From: Martyn White <Martyn.White@arun.gov.uk>
Sent: 01 May 2020 10:55
To: Planning.Responses <Planning.Responses@arun.gov.uk>
Subject: AB/27/20/PL

AB/27/20/PL

6 The Old Slipway River Road Arundel BN18 9EY

New balcony (This application may affect the setting of the Arundel Conservation Area)

DRAWING
Second Floor Plan + Elevations
as Proposed

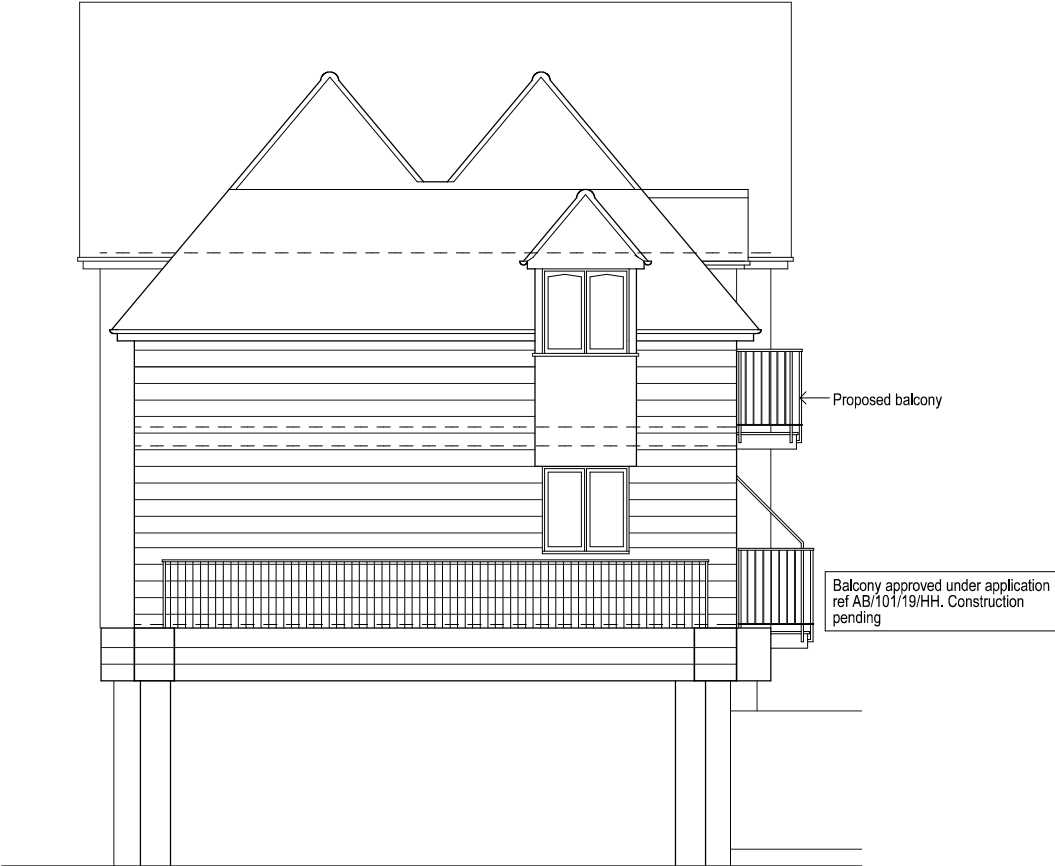
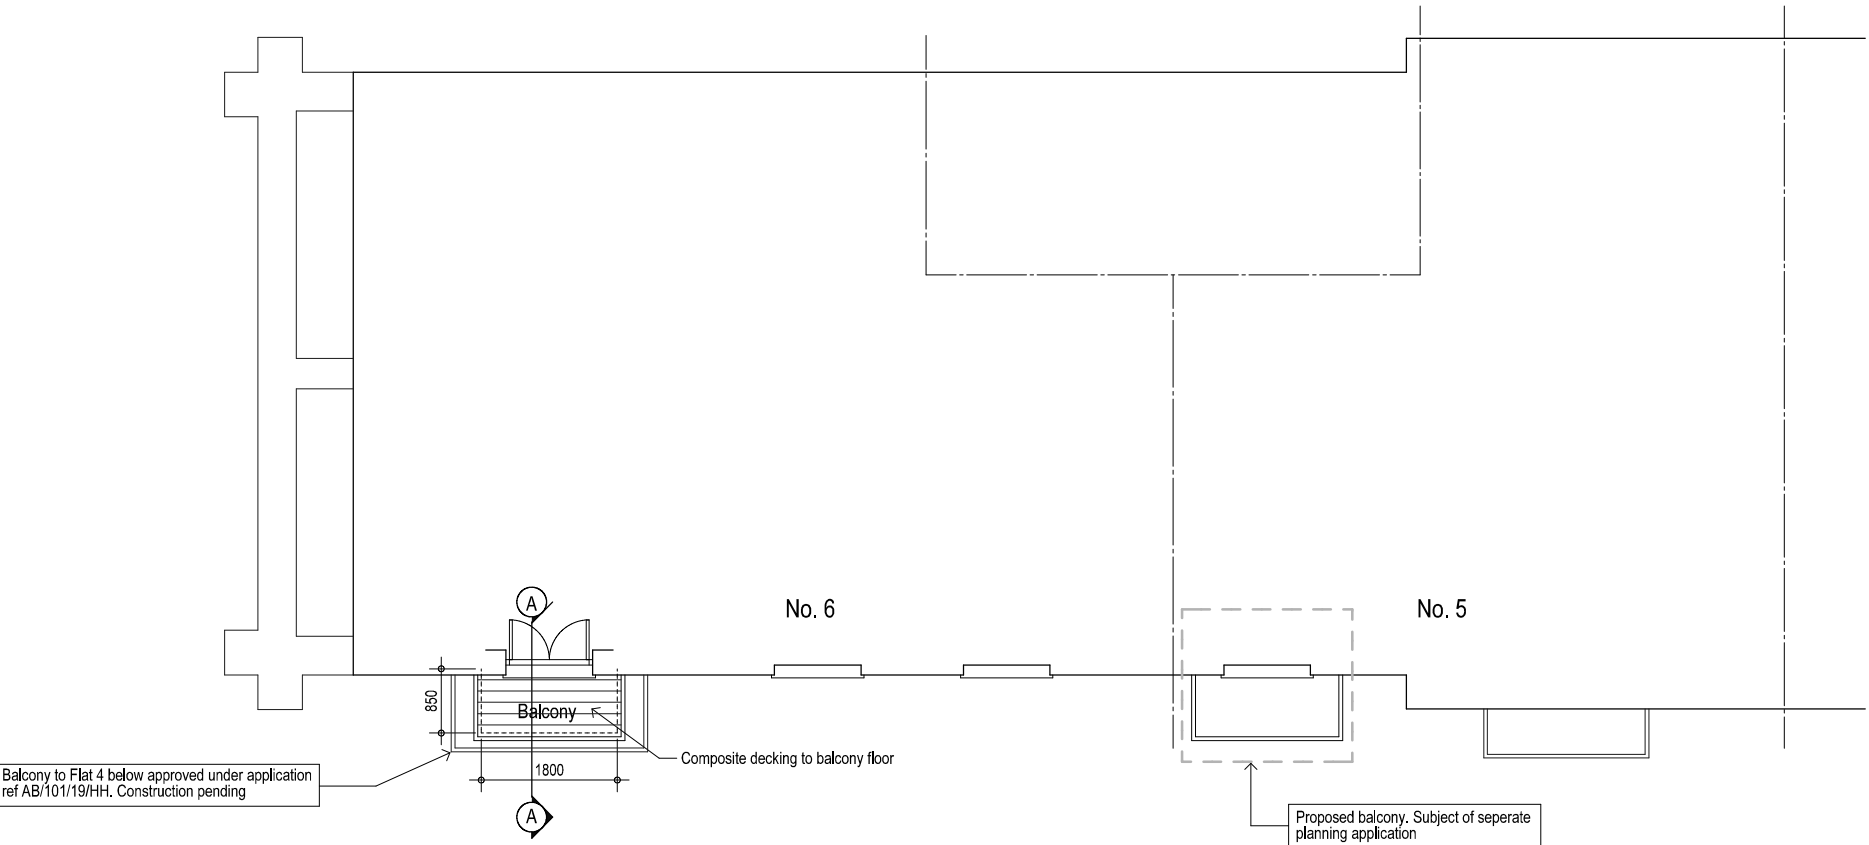
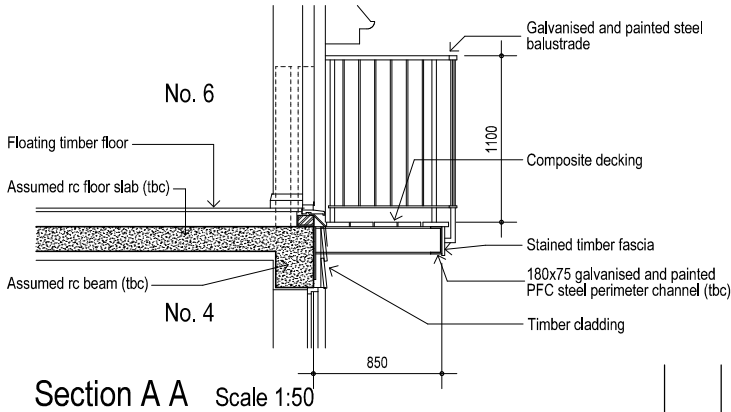
The proposal is to remove an existing south facing window and install inward opening French doors. A galvanised and painted steel balcony will be fixed to the face of the building.

It is considered that the proposal is of a scale which will not harm the appearance of the building or the character of the local area. The new French Window should match the existing joinery in terms of appearance, and colour. Likewise, the balcony should also be the same colour as those already present.

It is noted that there is also a separate application for the same proposal in another apartment within the building. When considered together, the proposals will maintain the symmetry of the façade, and it would be preferable if they were implemented at the same time.
